**KIRKLEES METROPOLITAN COUNCIL
INVESTMENT & REGENERATION SERVICE**

**DELEGATED DECISION TO DETERMINE PLANNING APPLICATIONS TO
CARRY OUT DEVELOPMENT WITHOUT COMPLIANCE WITH PLANNING
CONDITIONS PREVIOUSLY ATTACHED**

Reference No:	2024/70/93464/E
Site Address:	adj, 33a, Church Lane, Clayton West, Huddersfield, HD8 9LY
Description:	Variation condition 2 (plans) on previous permission 2023/91483 for demolition of garage and erection of detached dwelling
Recommending Officer:	Elenya Jackson

Proposed site plan (1:100)

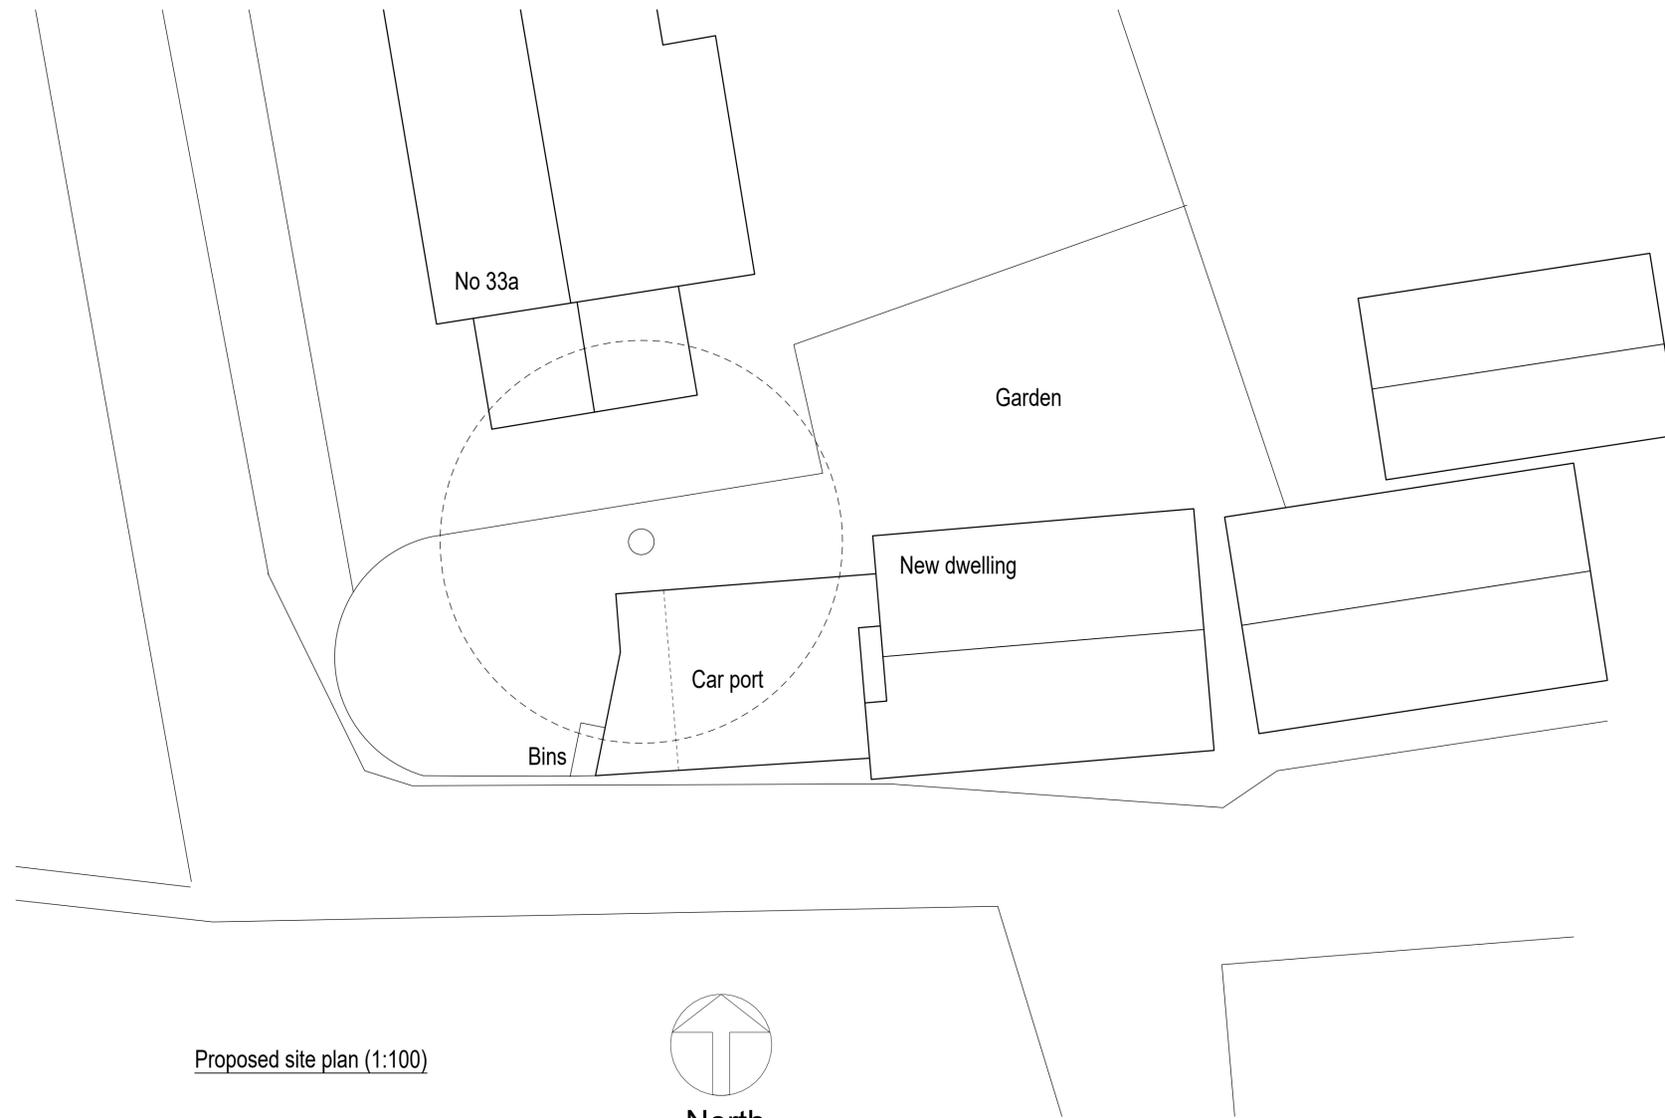
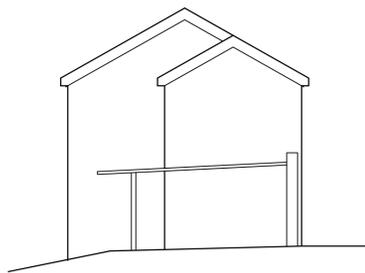
This variation would widen the width of the previously agreed car port to 7.7m from 5.8m.

This application has been received to revise the width of the proposed car port due to issues arising when the Swept Path Analysis was conducted to discharge other conditions attached to the original permission.

Officers have reviewed the plans and consider that the alterations would not have a significant impact on the visual aspects of the proposal as it would not significantly impact how the proposal would be perceived from the public realm.

Officers have informally discussed the application with KC Trees who have confirmed that providing the carport is constructed using the previously agreed cellular confinement system, no significant concerns would be raised regarding the proposals impact on the protected trees within the site. There are further conditions outstanding relating but not limited to boundary treatments, contaminated land and a tree impact assessment.
